KITITAS COUNTY

DEPARTMENT OF PUBLIC WORKS

MEMORANDUM

TO: All Staff
FROM: Public Works Plan Review Team
DATE: November 17, 2025
SUBJECT: LPF-25-00006 Wildcat Plat

KITTITAS COUNTY	DATE	JOB NO.
DWN BY JCR/GW/DLP	10/2025	062984
CHKD BY DLP	SCALE 1" = 200'	SHEET 1 OF 3

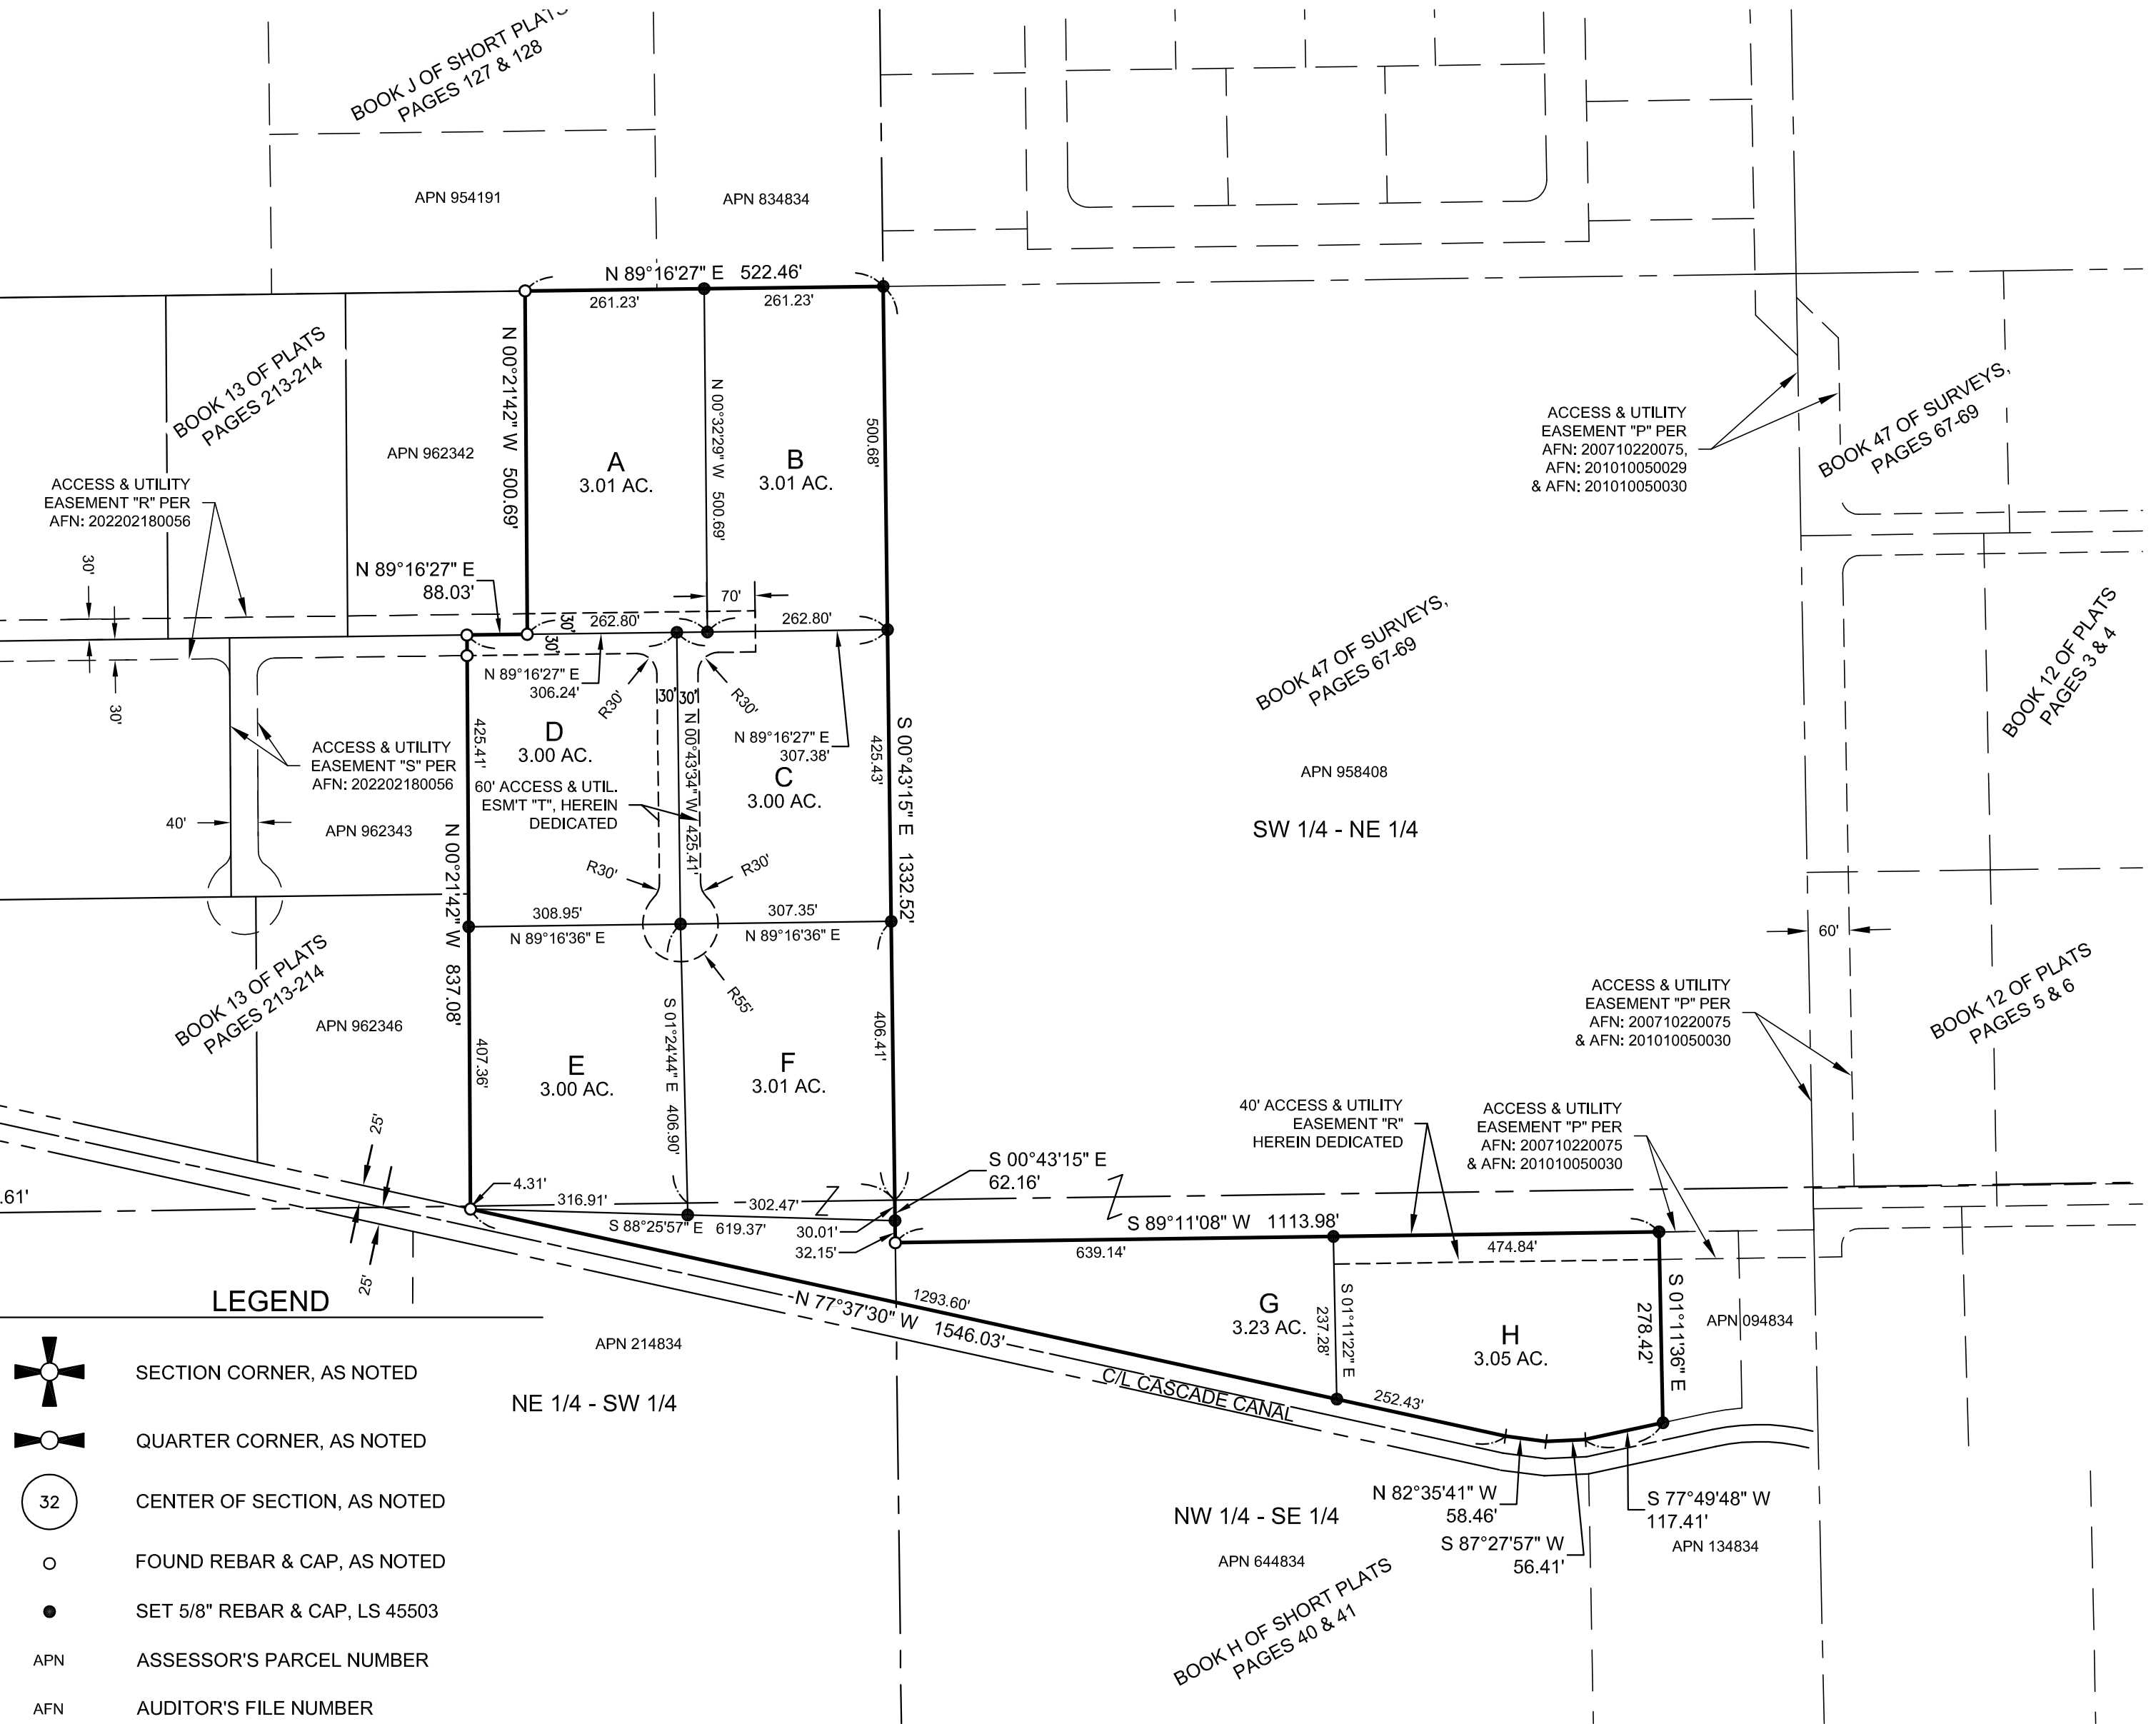
SURVEY	<p>1. Relating the linework between Sheet 1 and Sheet 3 is difficult. This could be made easier by labelling the center of section OR labelling the SW1/4 of NE1/4 on Sheet 1 (APN 958408).</p> <p>2. The N-S midline of section is shown as S00°43'17"E on sheet 3 and S00°43'15"E on sheet 1. (JT)</p>
TRANSPORTATION CONCURRENCY	<p>A concurrency evaluation and determination shall be required for all development applications in which the proposed development is projected to have an impact upon the transportation corridor or intersection.</p> <p>Developments generating 41 or fewer daily trips are exempt from the TIA and concurrency evaluation requirements. (KAH)</p>
FLOOD	<p>No comments. (SC)</p>
WATER MITIGATION/ METERING	<p>Water Mitigation and Metering requirements in KCC 13.35.027 have been met.</p> <p>No further comments. (SC)</p>
AIRPORT	<p>No Comments. (RC)</p>
